**From:** Laura Gibbons <Laura.Gibbons@arun.gov.uk>  
**Sent:** 05 October 2021 12:04  
**To:** Planning.Responses <Planning.Responses@arun.gov.uk>  
**Cc:** Simon Davis <Simon.Davis@arun.gov.uk>  
**Subject:** RE: Planning Re-Consultation on: AL/112/21/DOC

Thank you for re-consulting us on this application. We have the following comments on conditions 10-12.

**Site Address:** Springfield Hook Lane Aldingbourne PO20 3TE  
**Grid Reference:** 493480 104546  
**Category:** Discharge of Condi  
**Description of Works:** Approval of details reserved by condition imposed under AL/64/20/PL relating to conditions 10-surface water drainage, 11-discharge of flows & 12-surface water drainage system maintenance & management.

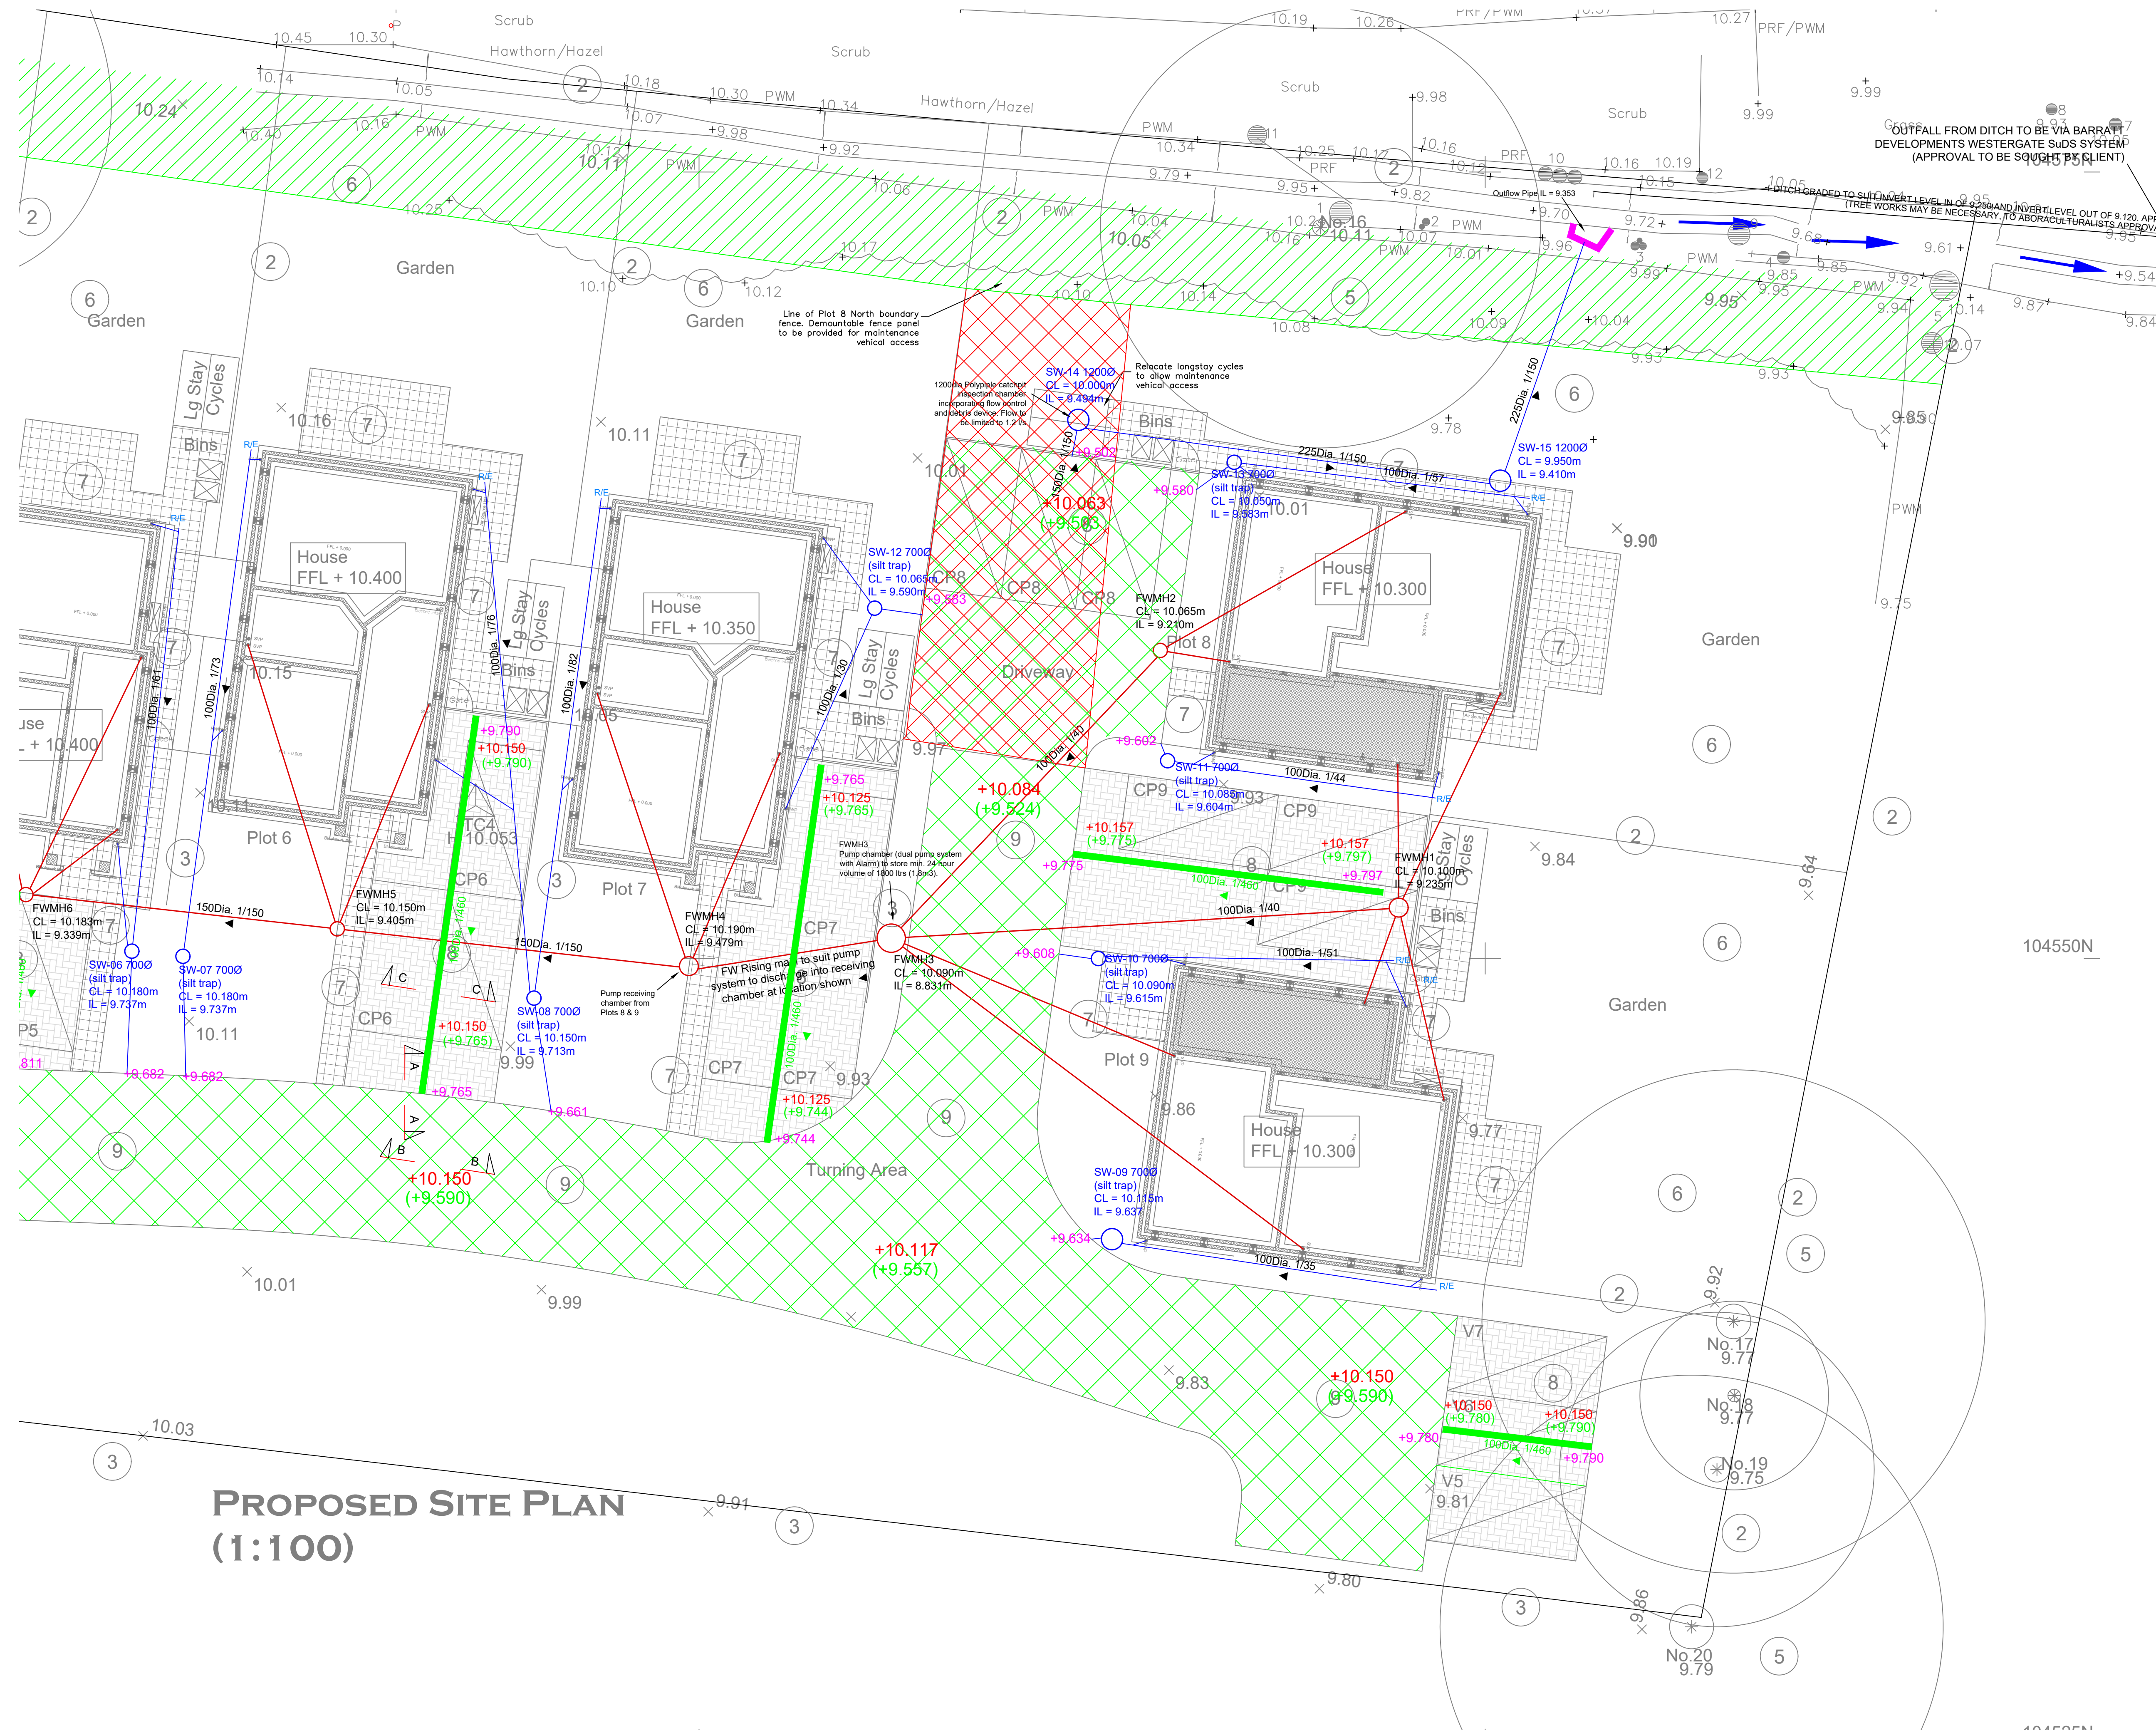
1. Calculations have now been submitted, however these do not include a surcharged outfall as requested previously (point 2 in response of 14<sup>th</sup> September). A surcharged outfall must be modelled with water level set to the top of bank of watercourse level.
2. Winter groundwater monitoring for the period 30/01/21 to 13/03/21 has been supplied. As have flotation calculations. These show the design to be adequate, even if groundwater rose slightly above that recorded.
3. The unit reference of the hydrobrake must be referenced on both the construction detail drawing and layout. Hydrobrake reference number must be consistent with calculations.
